DRB Application No.: 03DRB-02069 (SBP)	Project # 002874
Project Name: ATRISCO BUSINESS PARK	EPC Application No.: EPC03-CO1326
Agent: Sites Southwest	Phone No.: 822 8200

SUBJECT: COMMENTS ON #1002371 & #1002874

**Re: Request for final sign-off on site development plan for a temporary water pump station at 7901 Los Volcanes Rd., NW.**

EXISTING COCA COLA SITE PLAN WITH PROPOSED TEMPORARY PUMP STATION
SHT C2 OF 5
SEQ 3 OF 6

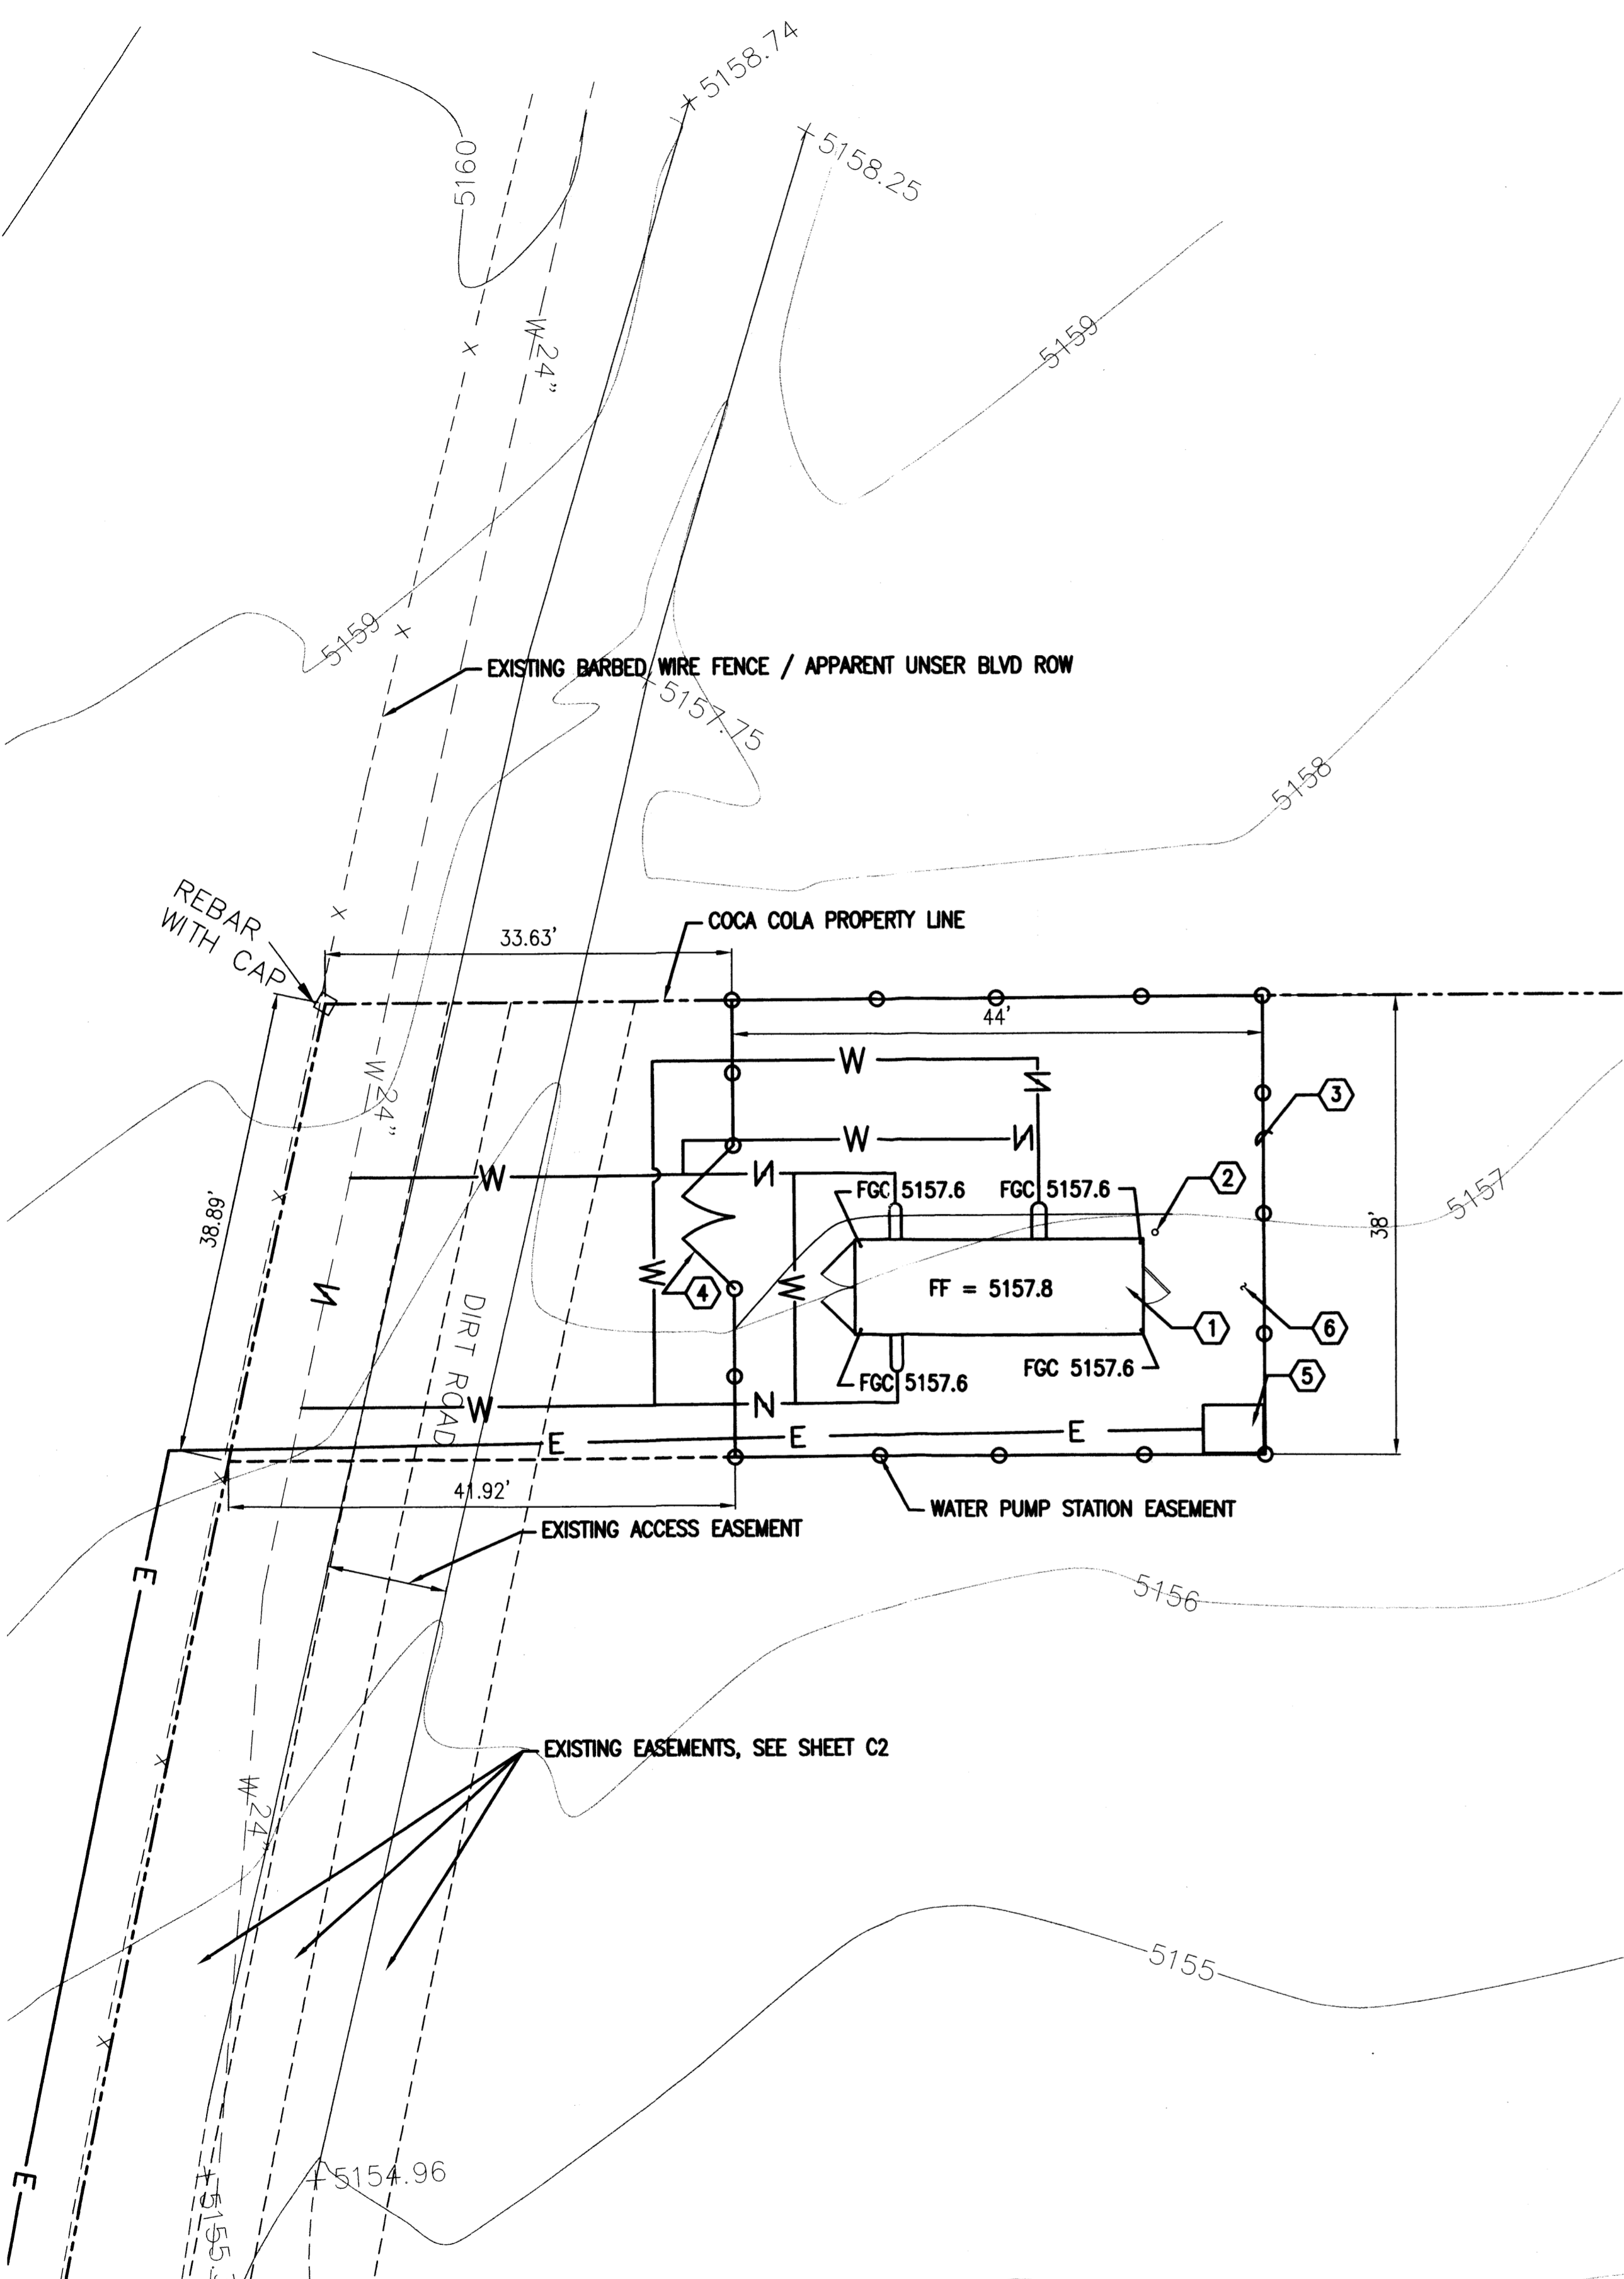
Pursuant to the condition of approval, the applicant has provided an adequate landscape plan. Nonetheless, the north arrow orientation on the site plan is different from that on the landscape plan, thereby reviewing the latter difficult. The north arrow should be consistent throughout the submittal.
